Monument Junction West Filing No. 1
Construction Documents Review (Streets, Storm Sewer and Final Drainage Report
Review) - Submittal 2

Date:	07/25/2022	Jacobs Engineering Group Inc.
Project no:	A.PN.CI.067	6312 S. Fiddlers Green Circle
Attention:	Debbie Flynn, Planner II	Suite 300N
Company:	Town of Monument:	Greenwood Village, CO 80111
Prepared by:	Mark Kitzmiller	United States
		T +1.720.286.2000
		www.jacobs.com

1. "Monument Junction West Filing No. 1 Construction Plan Set," by Classic Consulting, dated June 20, 2022.
2. "Final Drainage Report for Monument Junction West Filing No. 1," by Classic Consulting, dated July 2022.
3. CCES Responses to Submittal 1 review memo. **Note: Per e-mail attached, Jacobs did not have any comments on storm or pond plans.**

DRAWN BY	PRA	(H) 1" = 50'	SHEET 4 OF 13

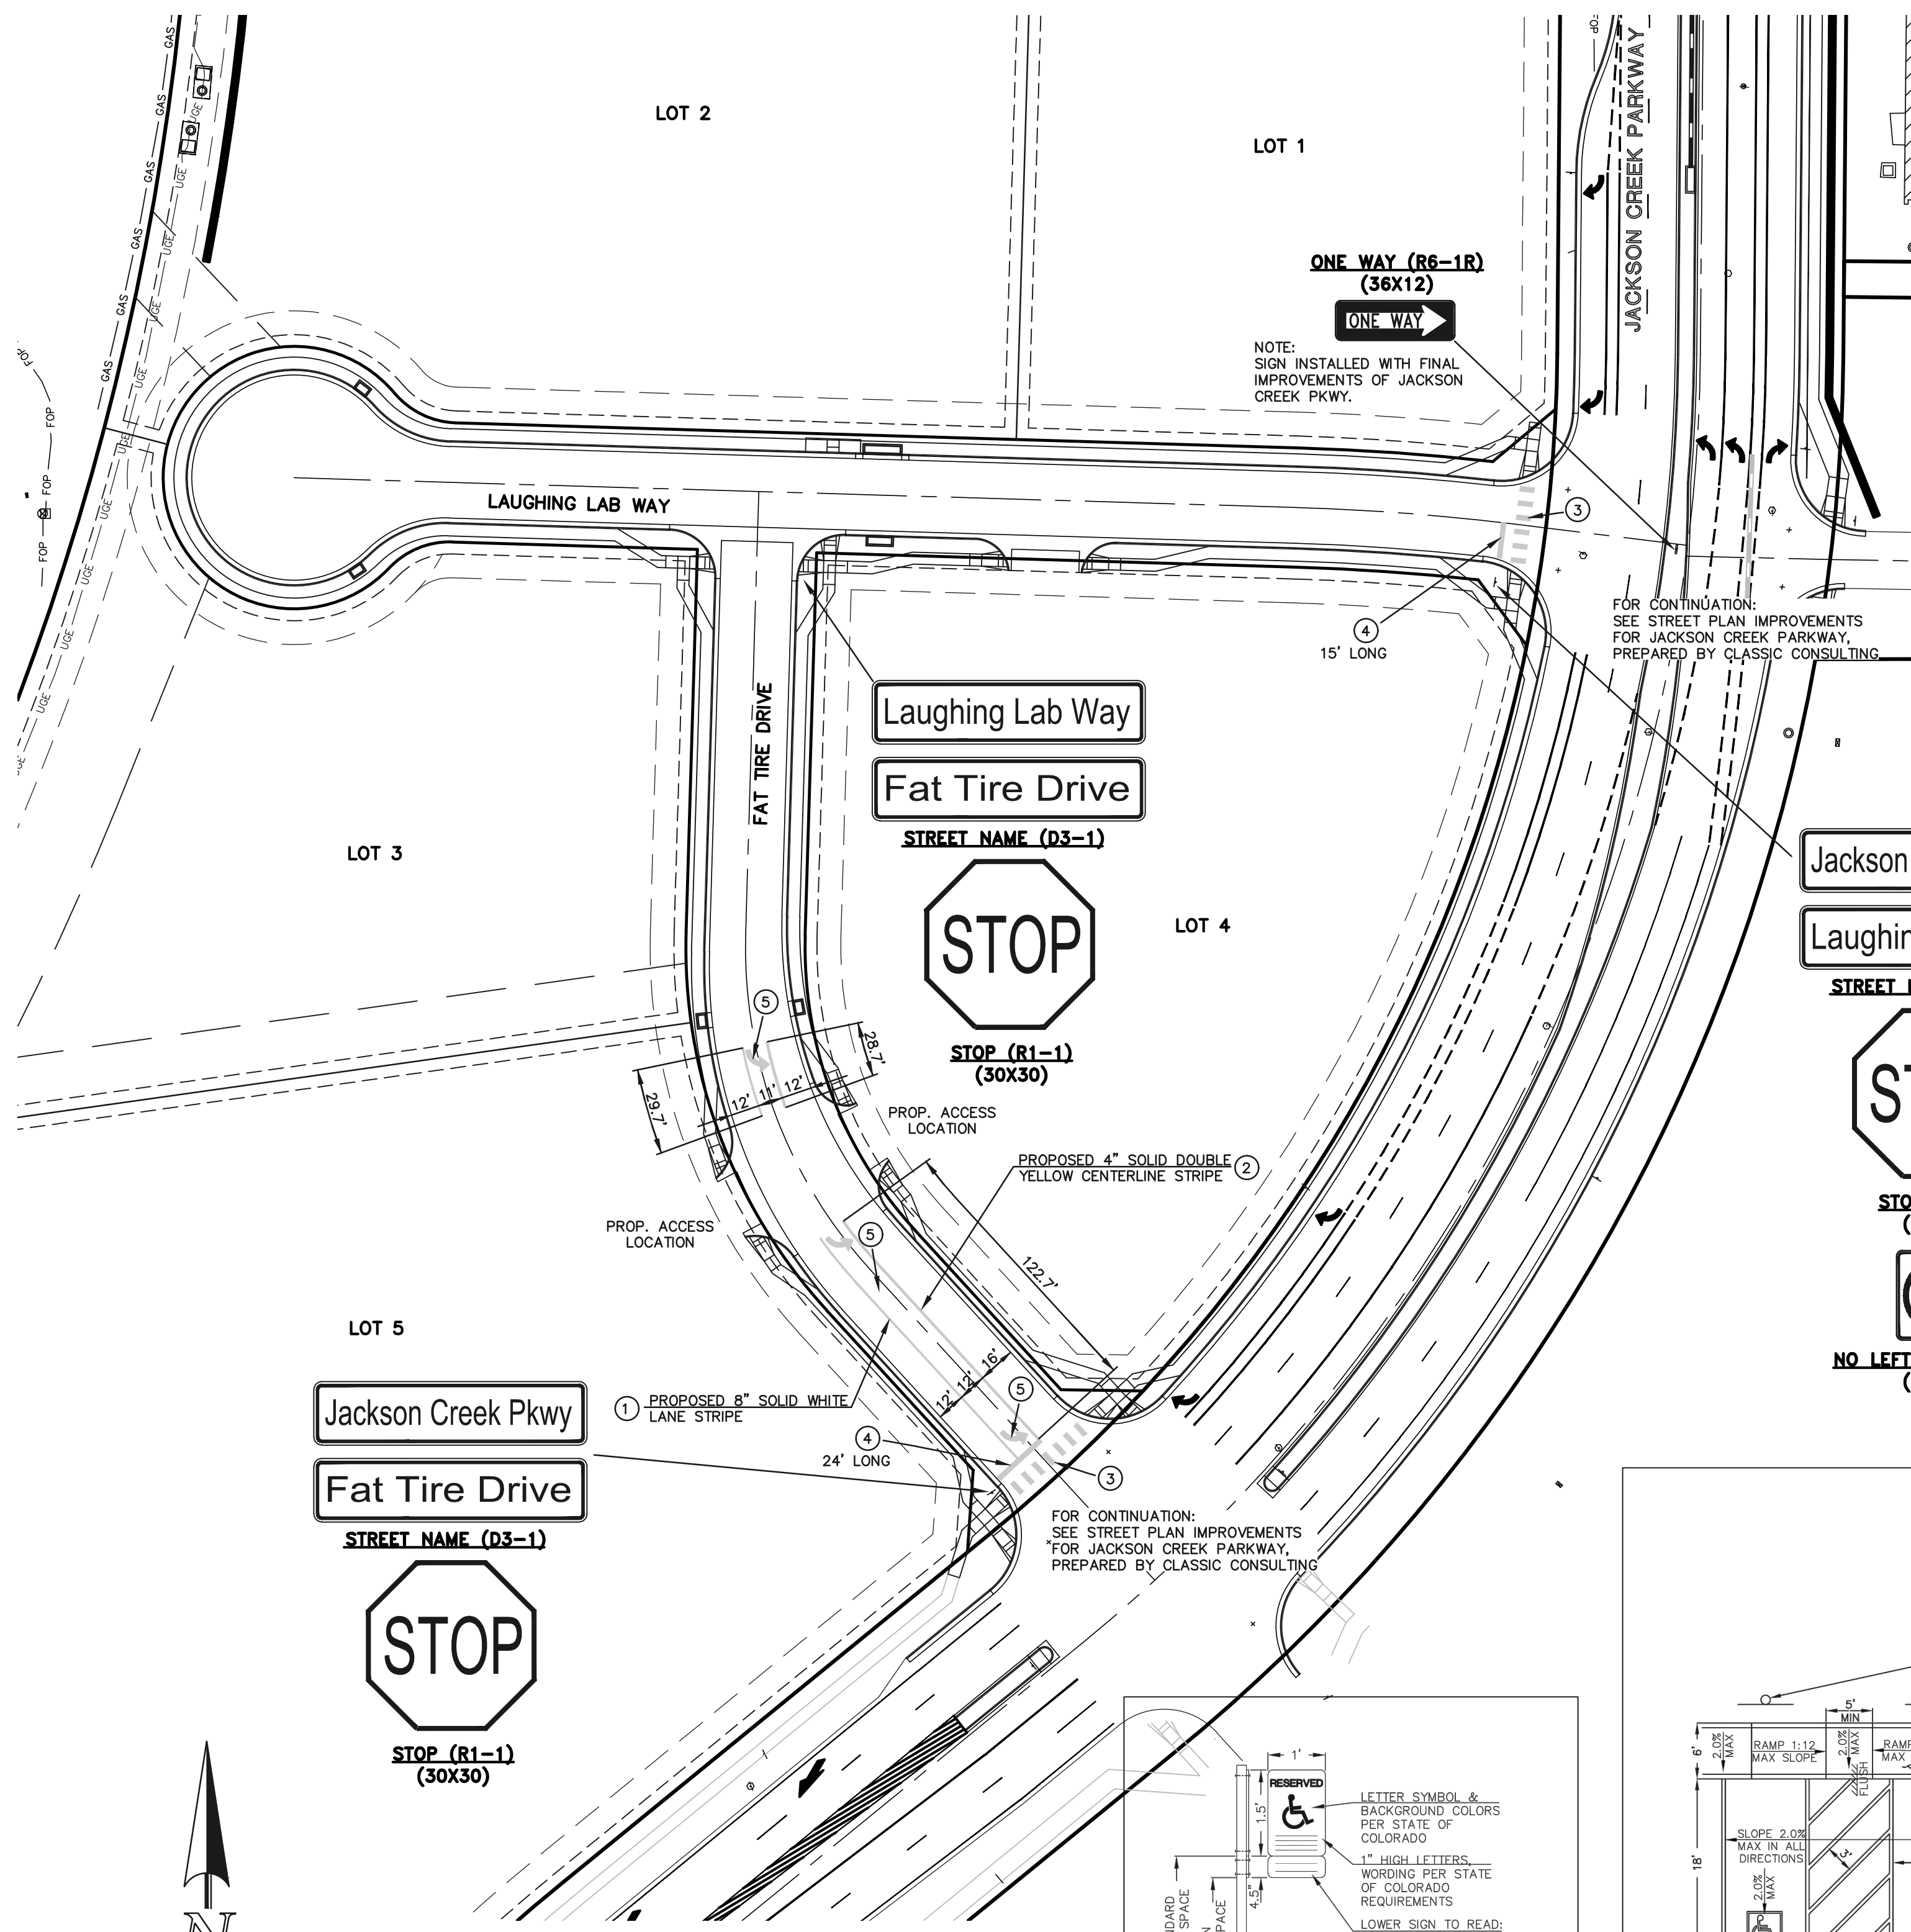
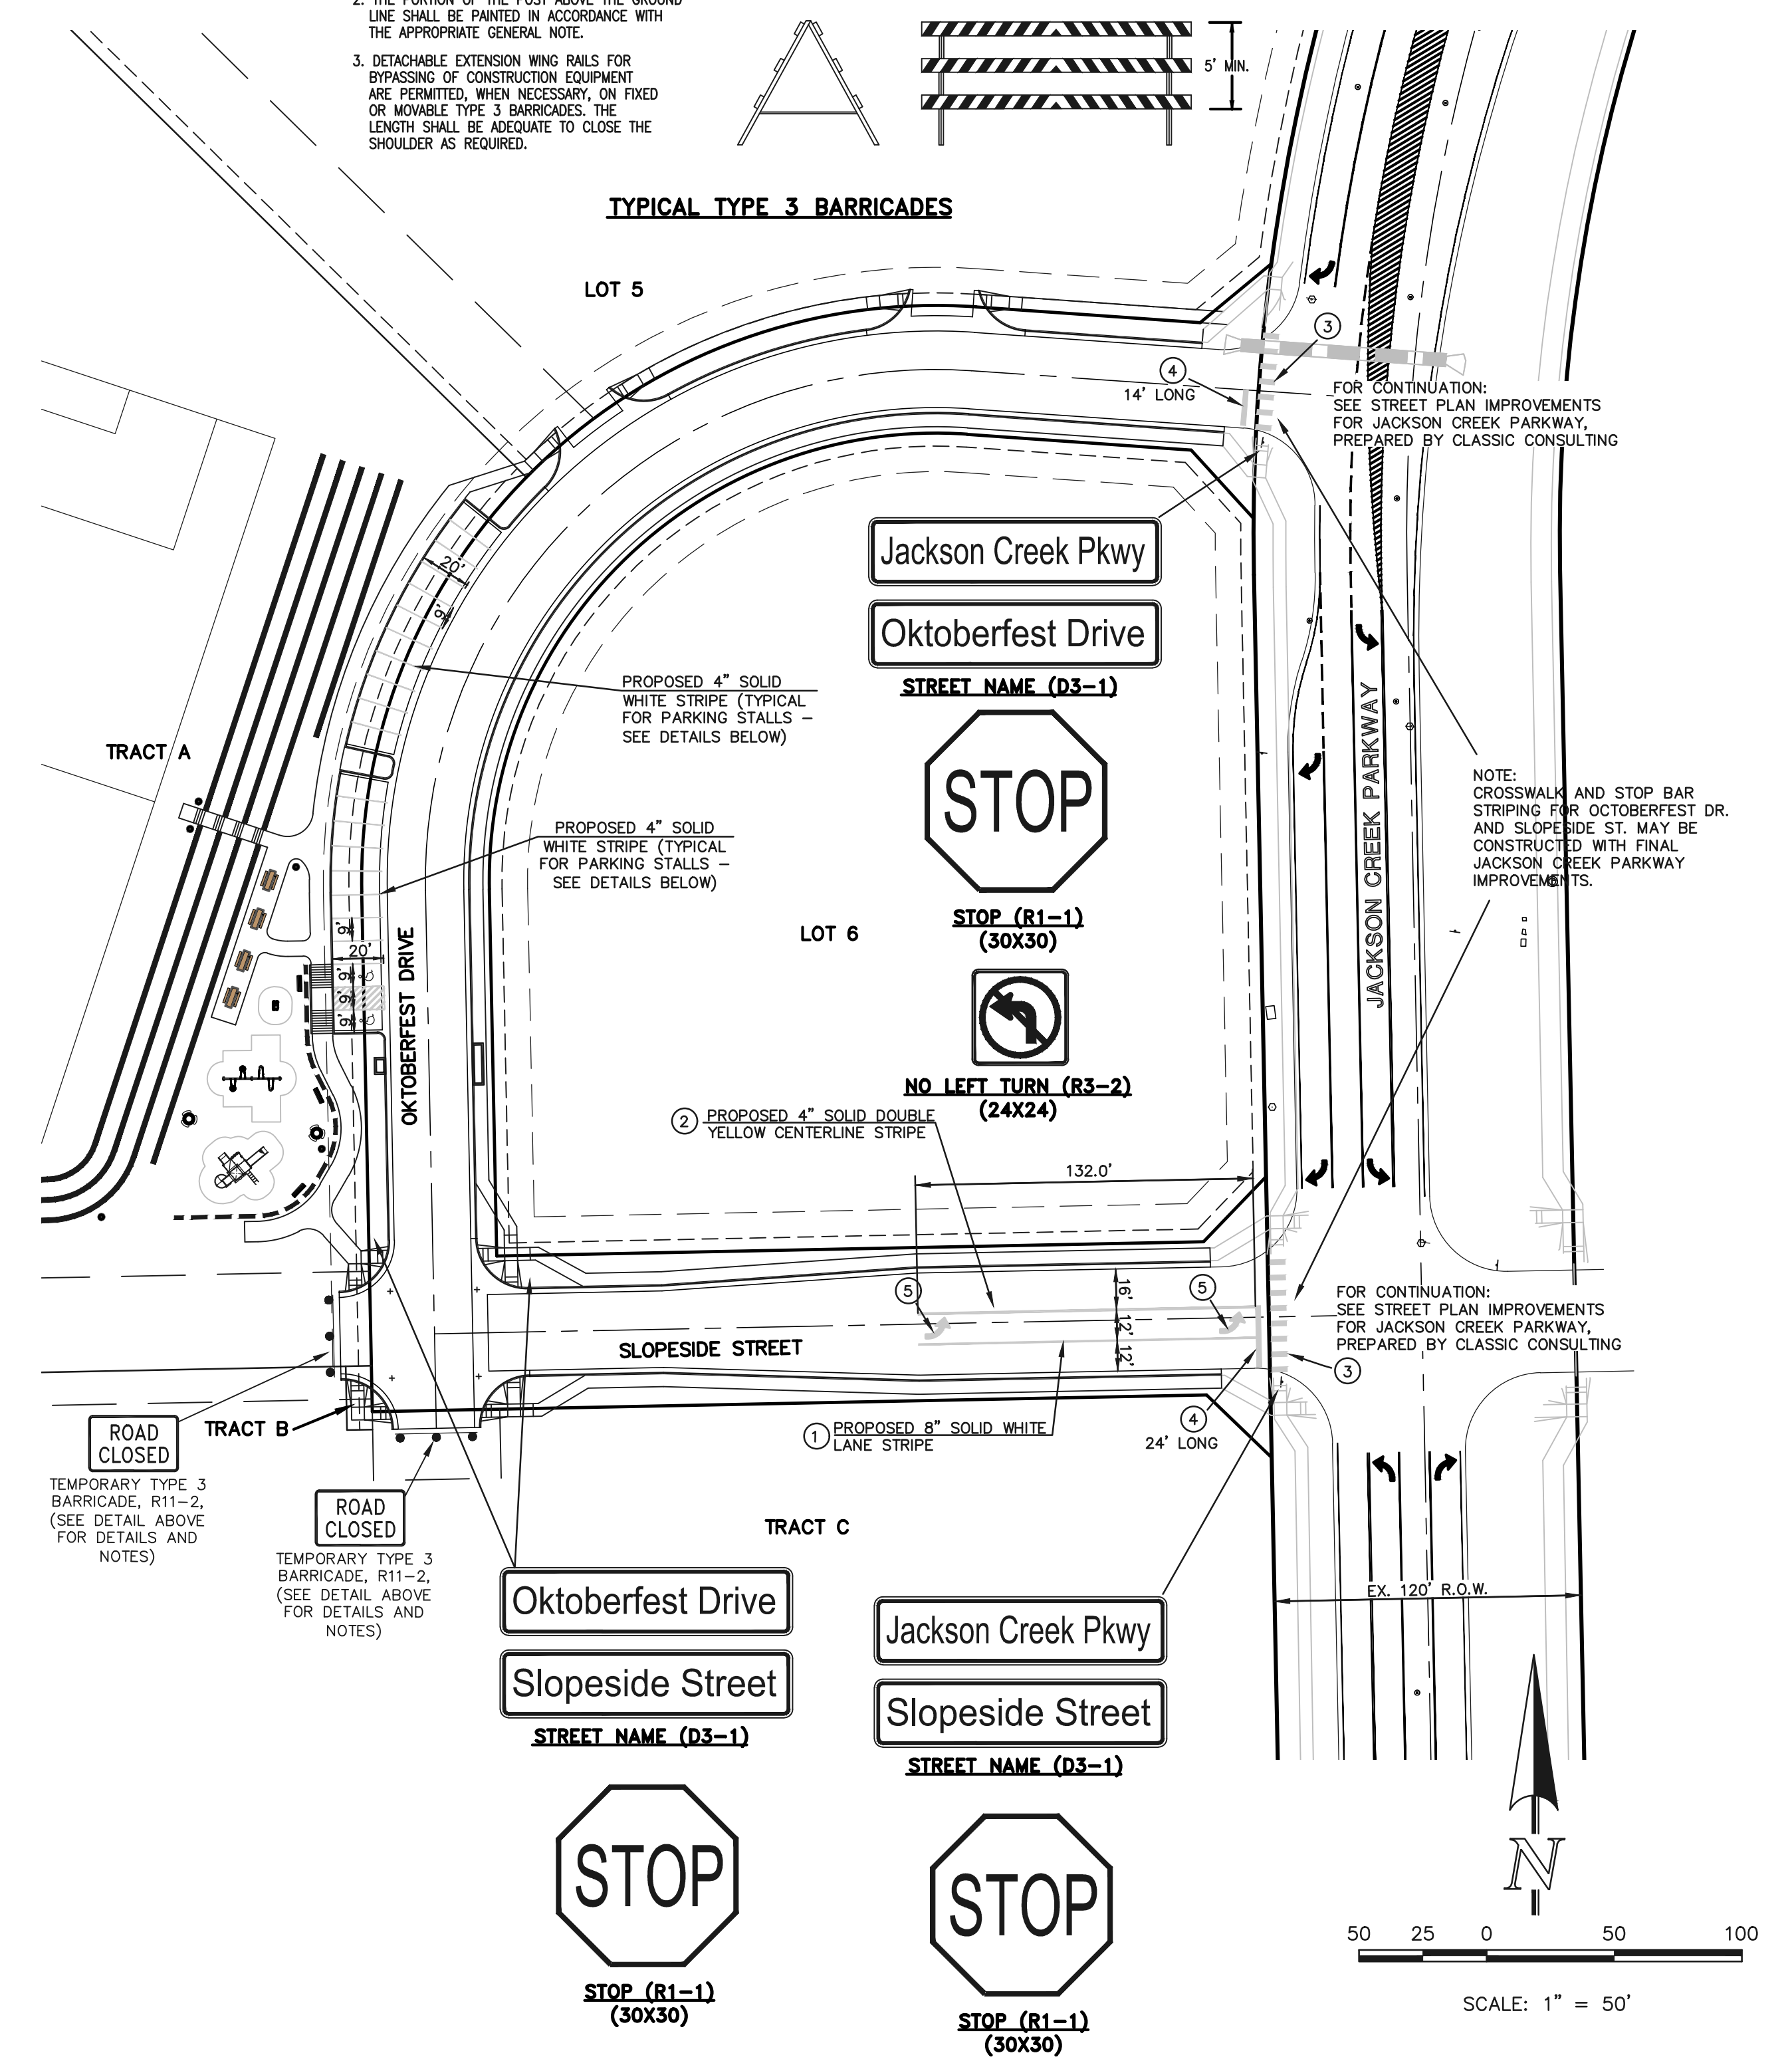
1. The Monument Junction TIS (LSC, Feb 2022) indicates that Fat Tire Dr. (Access B in the TIS) left-turn lane recommended storage be 200' so that LT's do not block the TH/RT vehicles. Has this length been accommodated? It's obvious the striping doesn't accommodate this but perhaps the roadway width does. **Addressed**
2. Add left turn arrows at beginning of left turn lanes, typical. **Addressed**
3. Add 8" before "SOLID" in the proposed solid white channelizing stripe callouts, typical. **Addressed**

4. Add 4" before "SOLID" in the proposed solid double yellow centerline stripe callouts, typical. **Addressed**
5. Add stop bars and crosswalk markings per town standards DT 33 on all roads intersecting with Jackson Creek Pkwy., if not included in those improvement plans. Turn lane striping should extend to stop bars once drawn in. **Partially addressed. Turn lane striping should extend to the stop bars (no gap). Crosswalk lines are to be 24" wide. Revised to 24" wide**

6. Add station and offsets or something to include where striping begins and ends. **Addressed**
7. The sign shown at the end of Oktoberfest Dr. on the barricade does not match the detail or the sign code (R11-2) shown. Please update sign to match detail. Message should be ROAD CLOSED, unless you're letting general traffic (not construction vehicles) past the barricade. **Addressed**

8. The detour sign shown on the barricade detail is not needed. Please remove. **Addressed**
9. **New Comment: add "Town of Monument Standard DT 33 and" to *Note in Striping Legend. Added**

10. **New Comment: Are the parking spaces shown along Oktoberfest Drive part of this submittal? If so, stall dimensions, striping details, etc., should be provided. Added**
